## CITY OF PORTLAND

July 13, 2004

RE: 328 Island Avenue, P.I. – 087-R-002 – IR-2 Zone – Shoreland Zoning – Floodplain

MEAN HIGHWATER AS
OBSERVED ON 12/15/2003

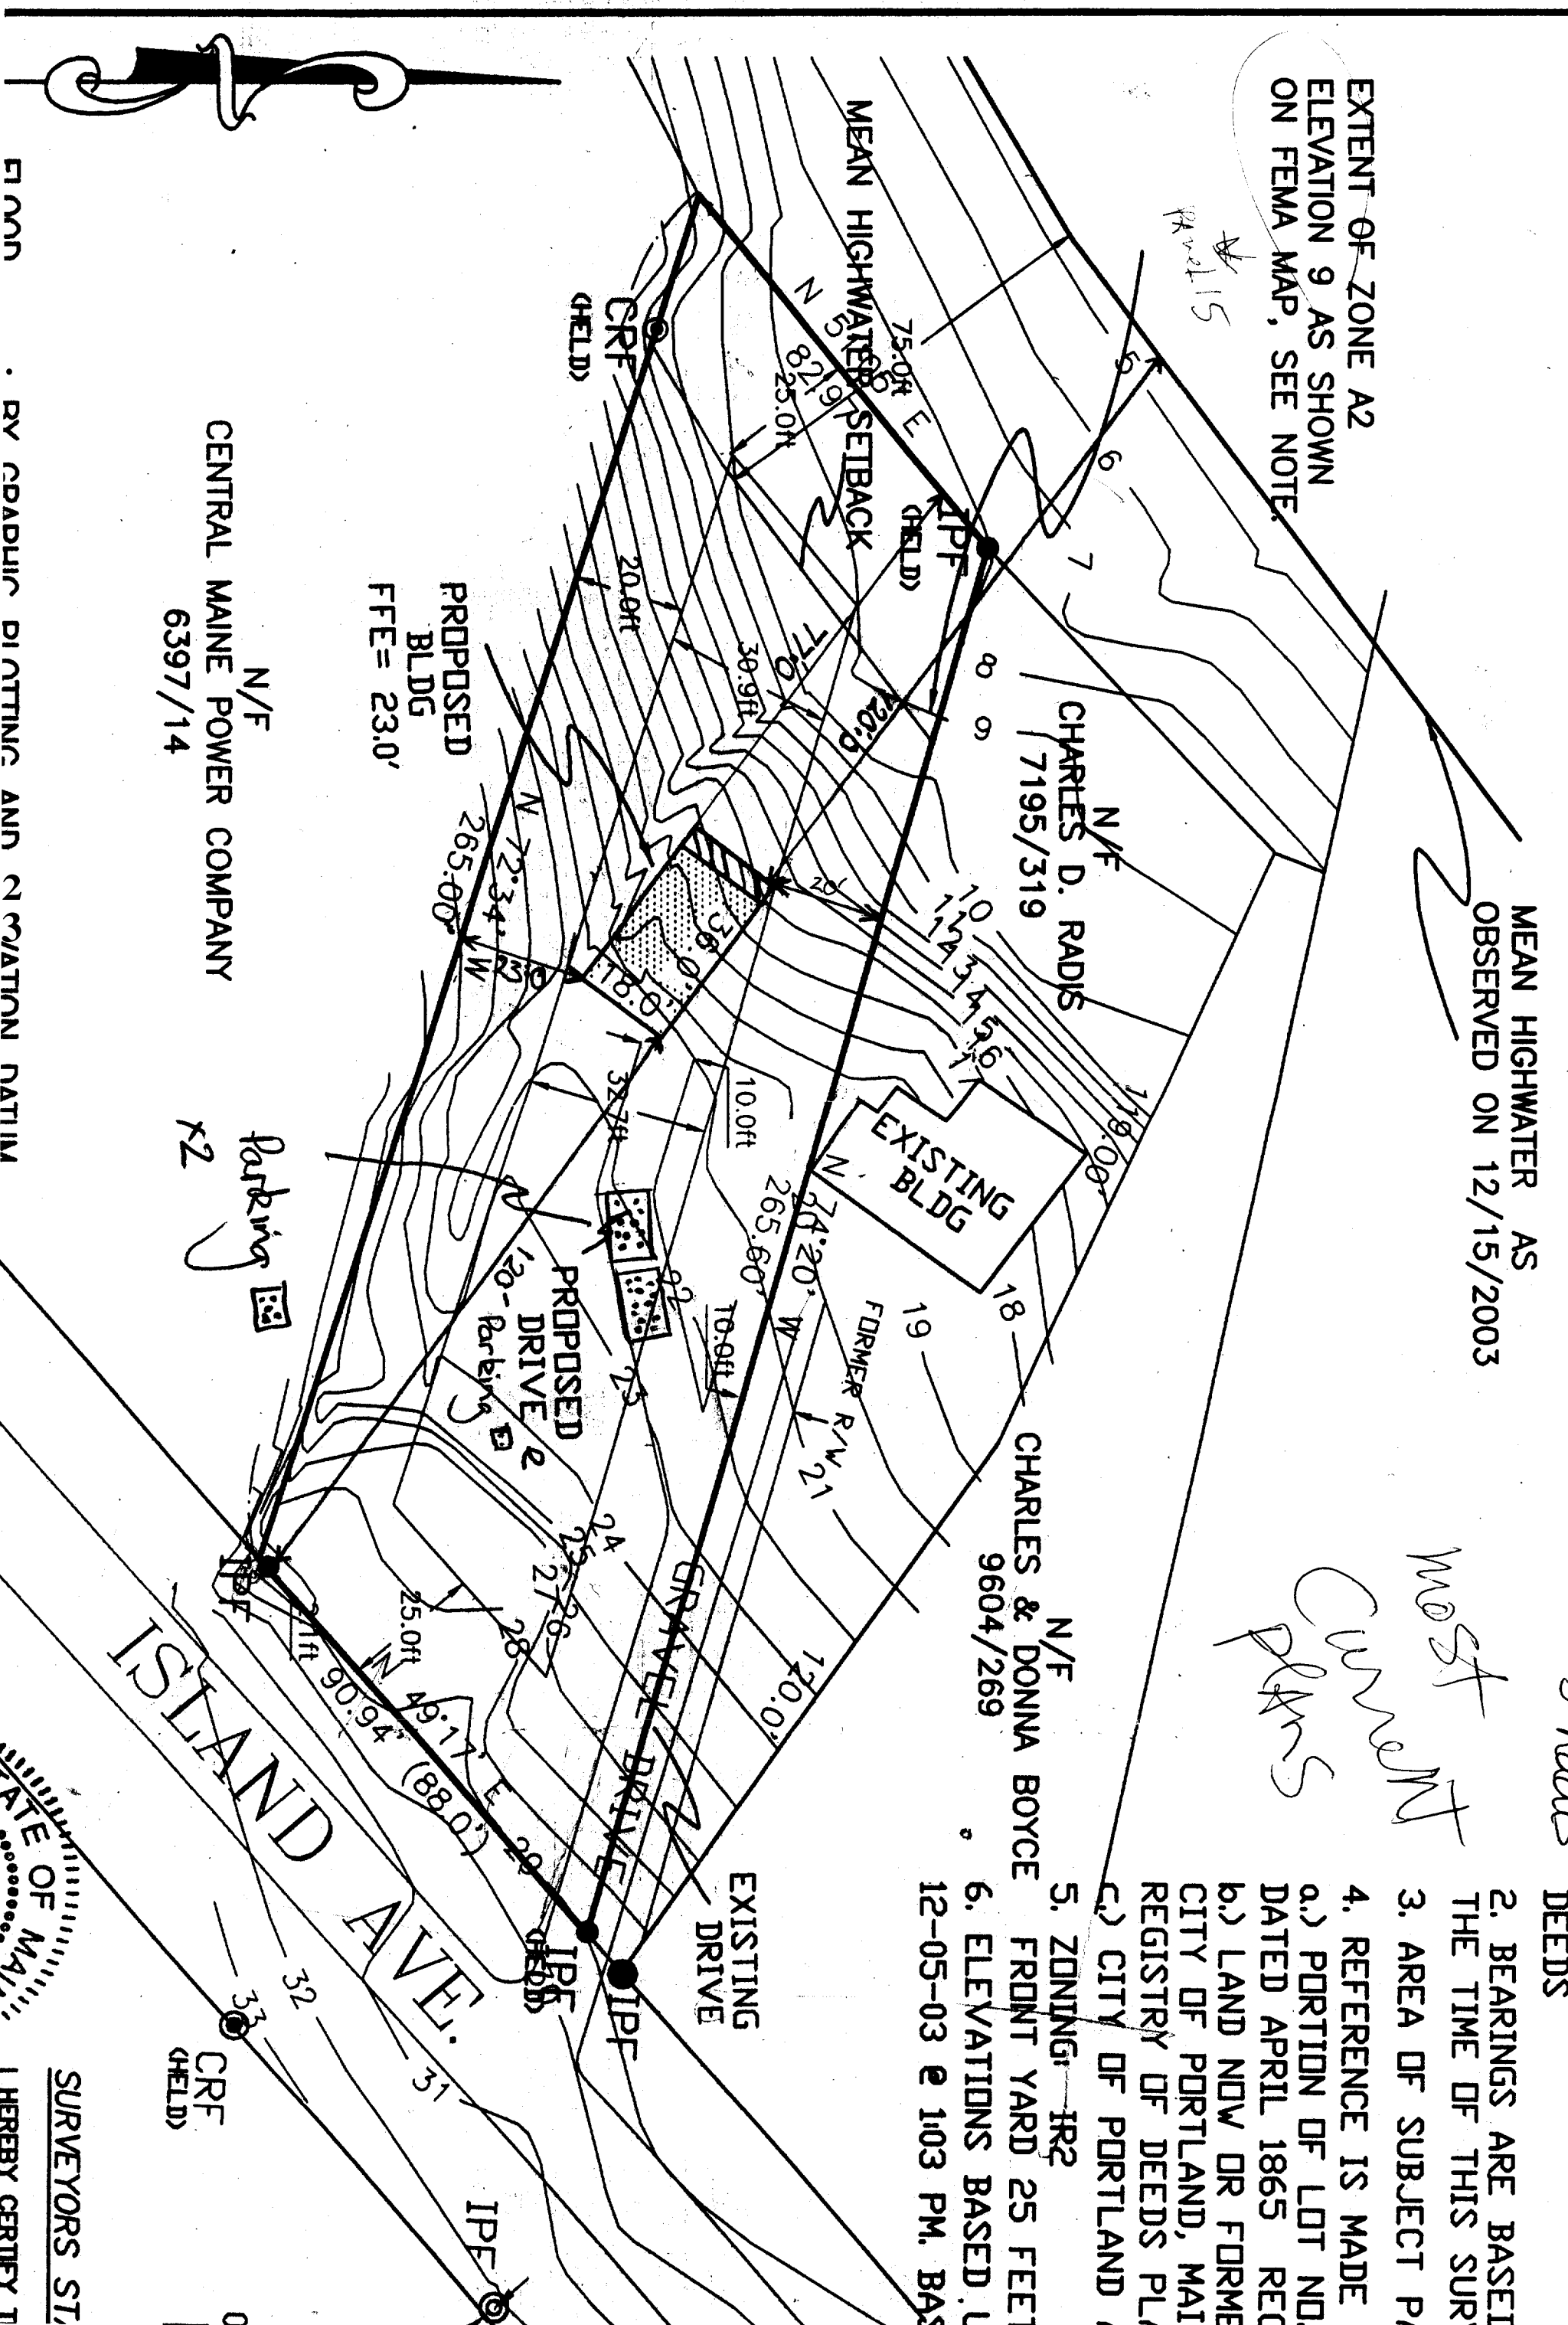
This property is located within the Shoreland Zone area. Section 14-449 of the Zoning Ordinance requires structures to be setback a minimum of 75 feet from the high water mark, instead of the 45 feet from the mean high water mark that you have shown on your plans.

Rad's
Boathouse
Elevation
1/4" = 1'-0"

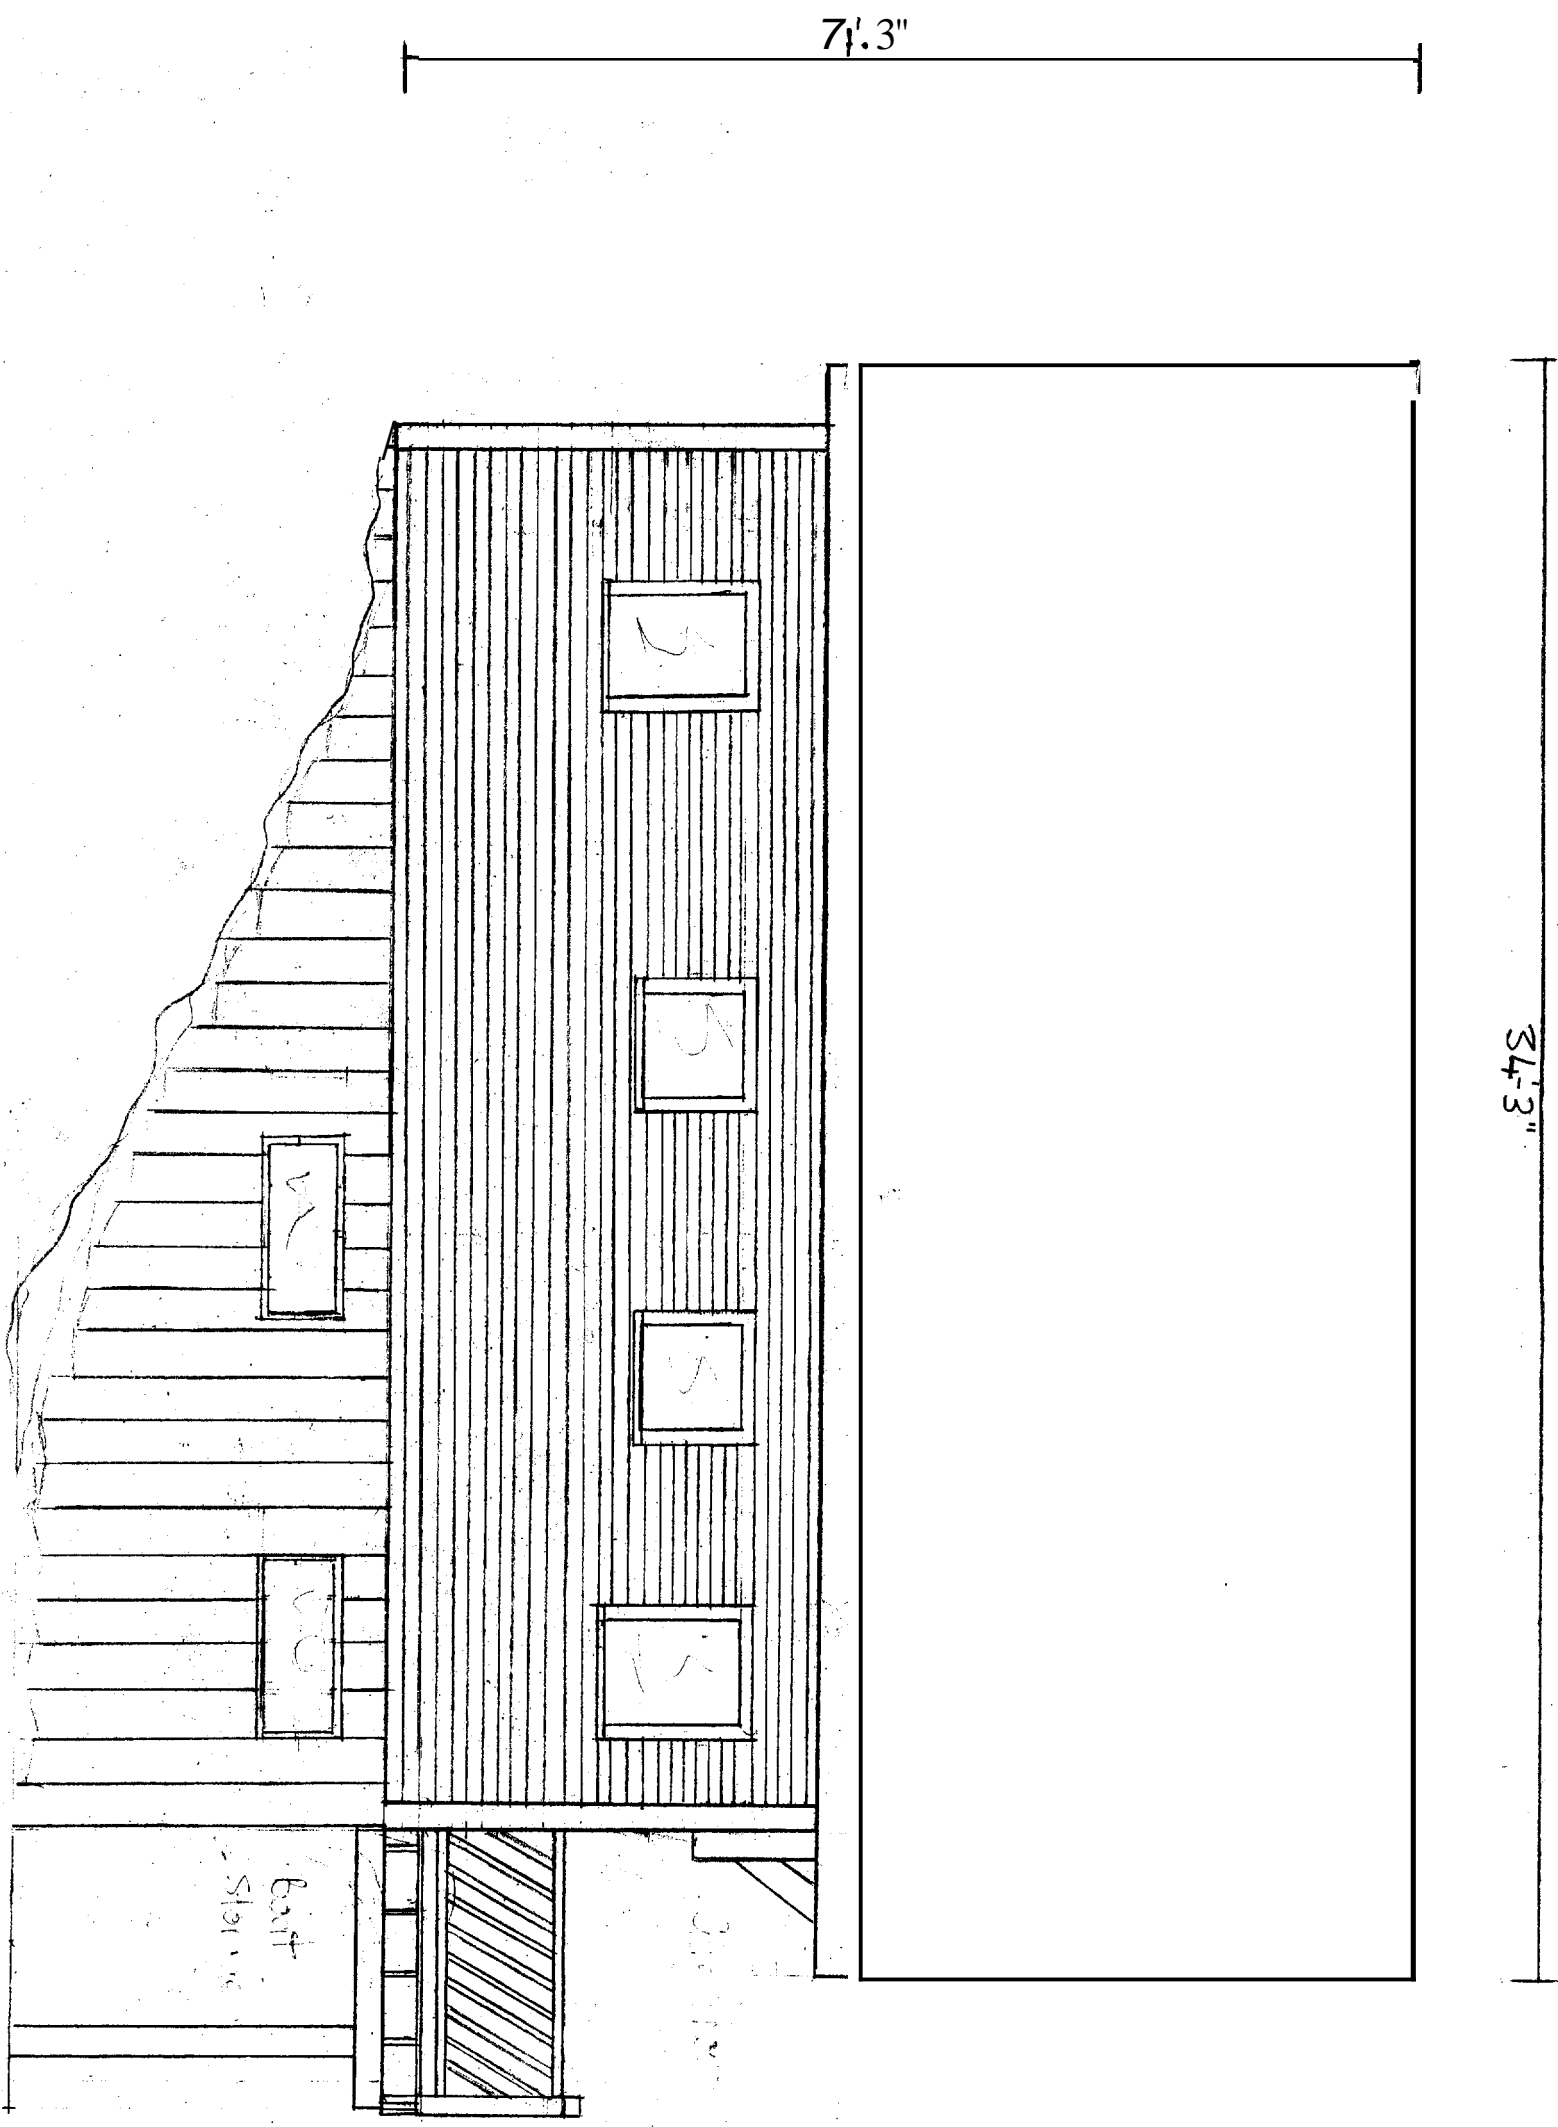
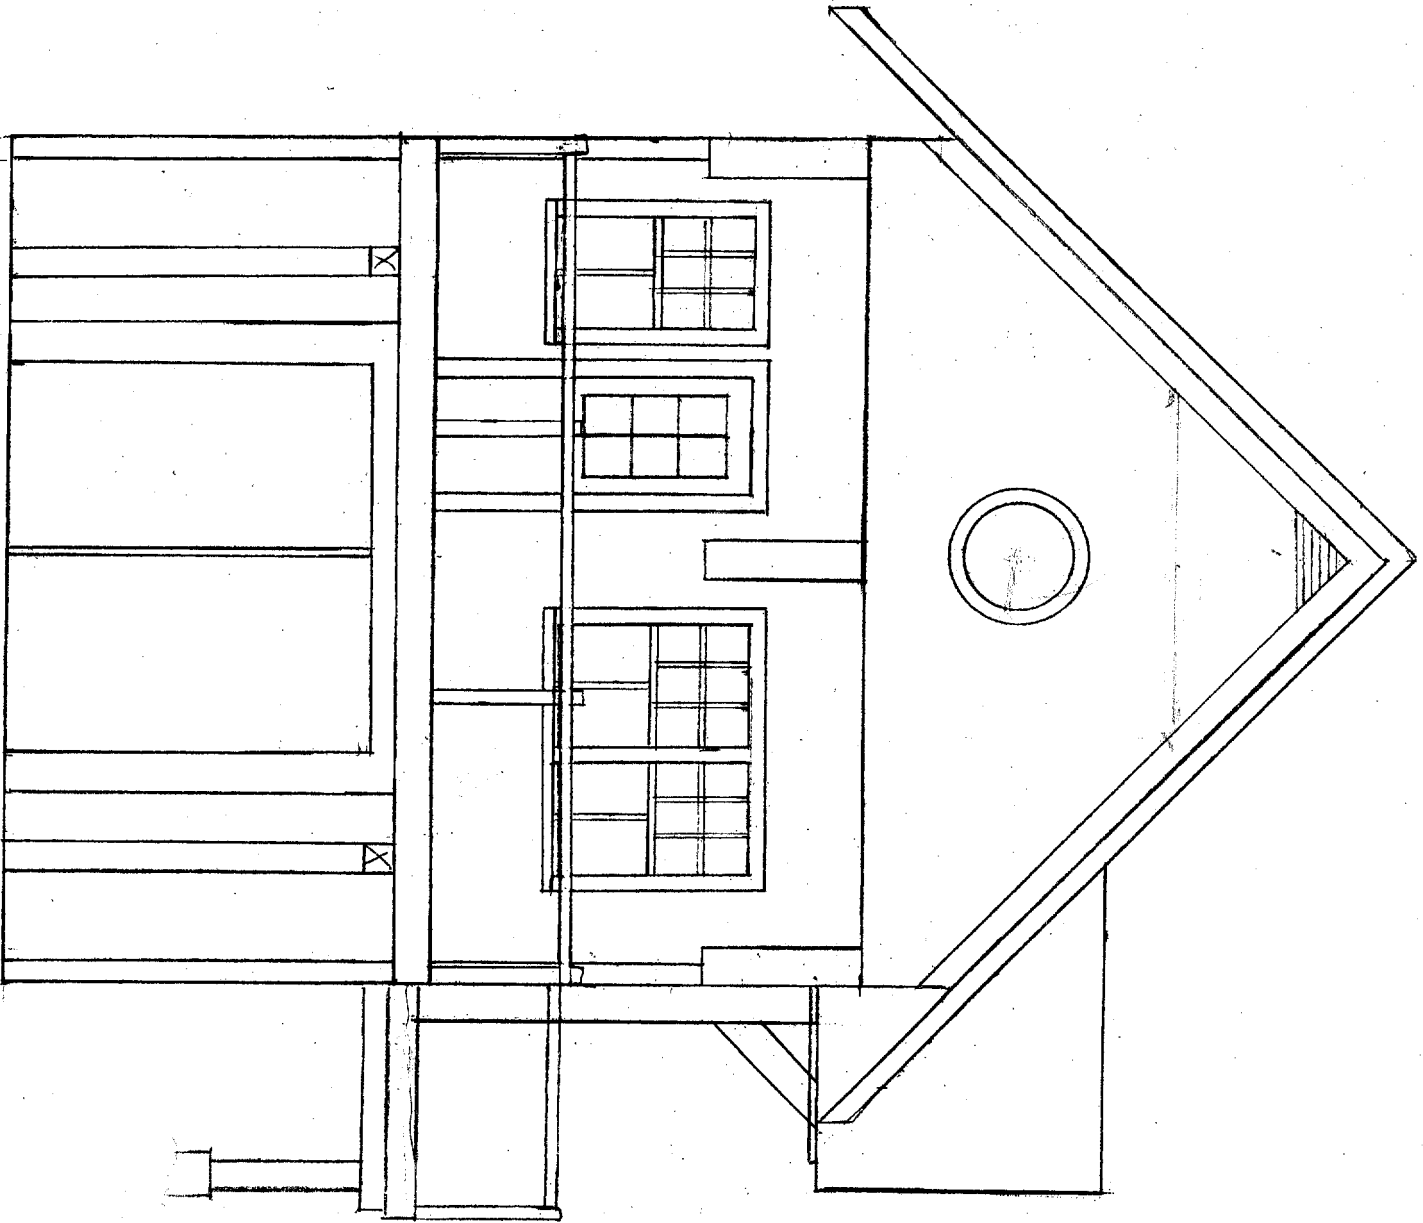
Section 14- 145.11 requires the maximum building height for a principal building to be no more than 35 feet from pre-development grade. This office has not been provided with any such

information. This office will require all predevelopment grades around the proposed house prior to any approvals.
